**Application Reference:** 2026/0248

**Site Address:** 24 Brunswick Close, Smithies, Barnsley, S71 1NQ

**Proposal:** Two storey side extension to dwelling

Drawing Title
PROPOSED ELEVATIONS

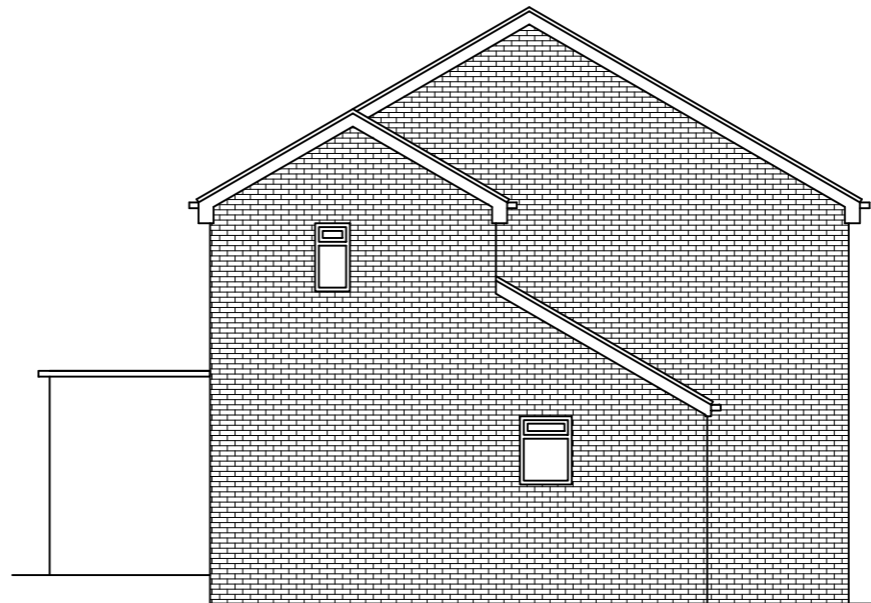
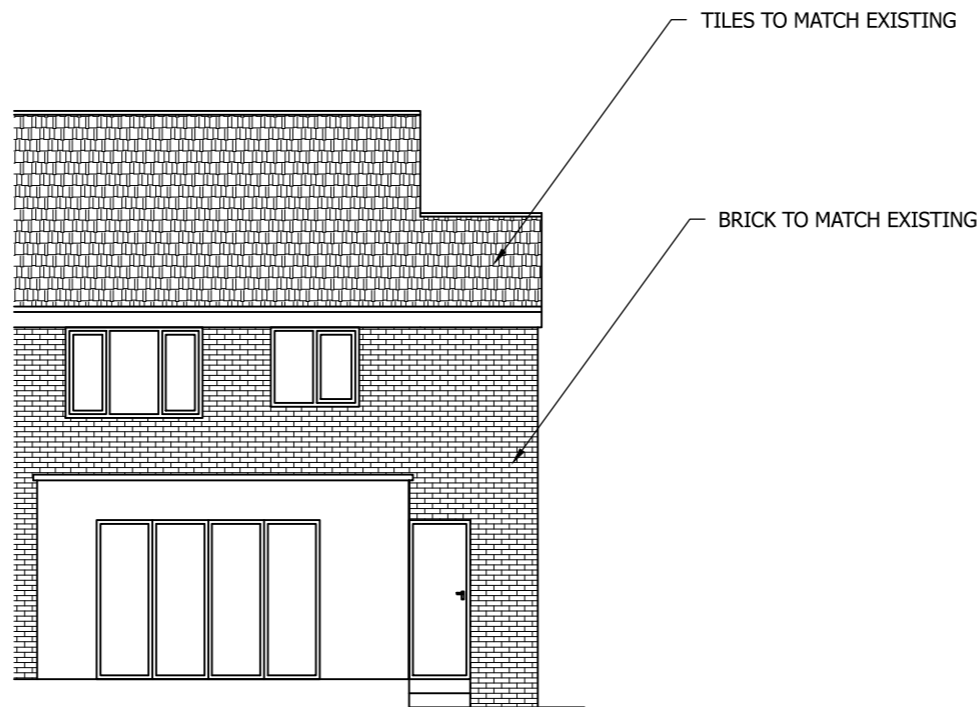
At approximately 1.7 metres, the proposal provides an acceptable sideways projection of less than two thirds the width of the existing dwelling. The extension is set back from the front elevation at ground floor level by approximately 1.9 metres and at first floor level by

approximately 4.6 metres. These are significantly set back which reduces the impact of the proposal on the street scene. Additionally, the highest ridge of the proposal would be set down from the existing dwelling by approximately 1.3 metres. This ensures the proposal is subordinate to the existing dwelling and prevents the extension from having a dominant impact on the street scene. The use of a lean to roof form at ground floor level and a pitched roof at first floor level is in keeping with the character of the dwelling and the street scene. The front elevation at first floor level is noted to be small due to the pitch of the ground floor roof, however the side extension is significantly set back from the front elevation and would therefore have little impact on the street scene. The use of matching materials is welcomed and in keeping with the site and street scene.

The proposed front elevation glazing at ground floor level and first floor level is positioned centrally to the extension. The glazing at first floor level is noted to be small, however given the extension is significantly set back from the existing front elevation, this would not have a significant impact on the street scene.

Drawing No.	Rev No.
MIC001 -004

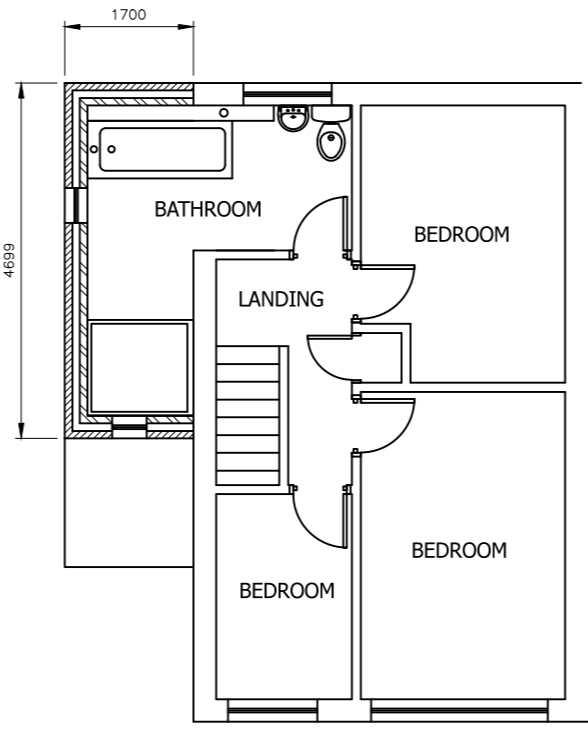
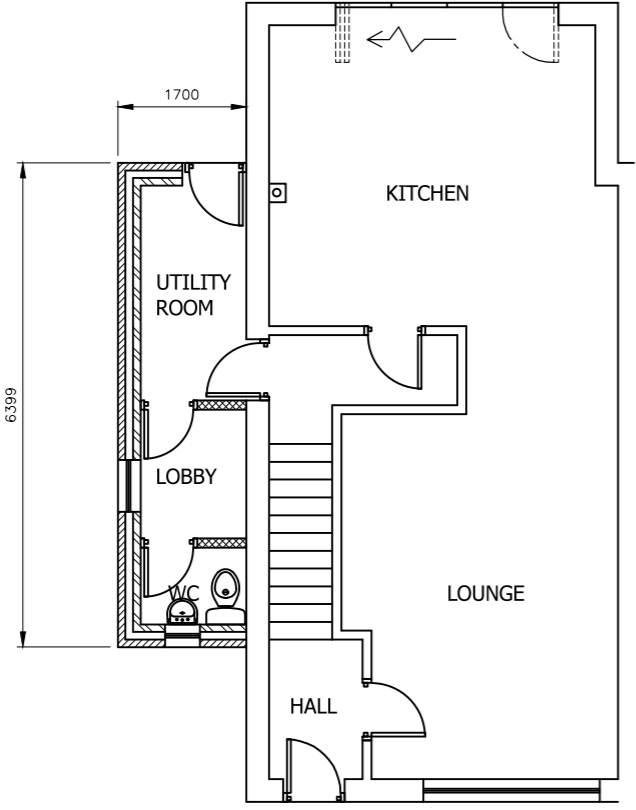
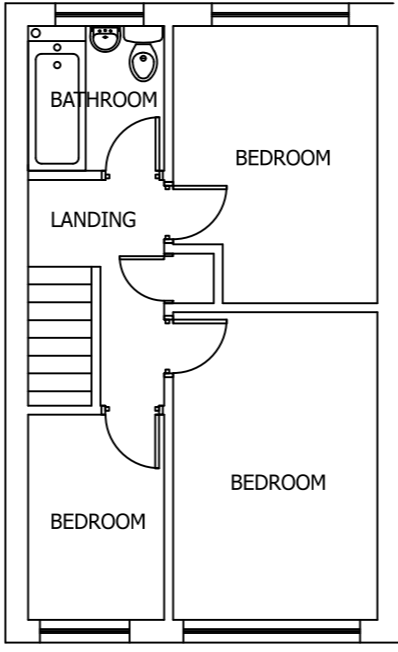
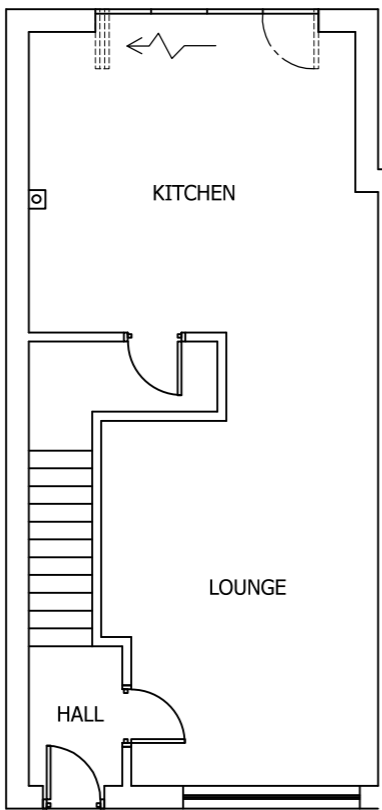
The proposed extension would be erected to the south of 26 Brunswick Close and distanced by approximately 0.65 metres to the neighbouring side elevation. Although the proposal is acknowledged to be in close proximity to the boundary, the proposal does remain within the boundary of the site and is in fact distanced away from the boundary, unlike the property to the north. There is not a requirement for proposals to retain a sufficient distance to allow for property maintenance, especially given the maintenance in this case would require access via the applicant property. It is acknowledged that the proposal would reduce light to the side elevation window of the neighbouring property; however, the window in question is small and obscured and does not serve a habitable room. The loss of light would therefore not be considered to have a detrimental effect on the residential amenity of the neighbour and given the window is obscured, would not impact upon loss of outlook. Furthermore, it is acknowledged a similar extension could be erected in the same location which would impact the neighbouring window in the same way under permitted development.

Given the proposed ground floor window and first floor window will service a W/C and a bathroom respectively, both will be conditioned to be obscured glazing in order to protect the residential amenity of the applicant and any members of the public.
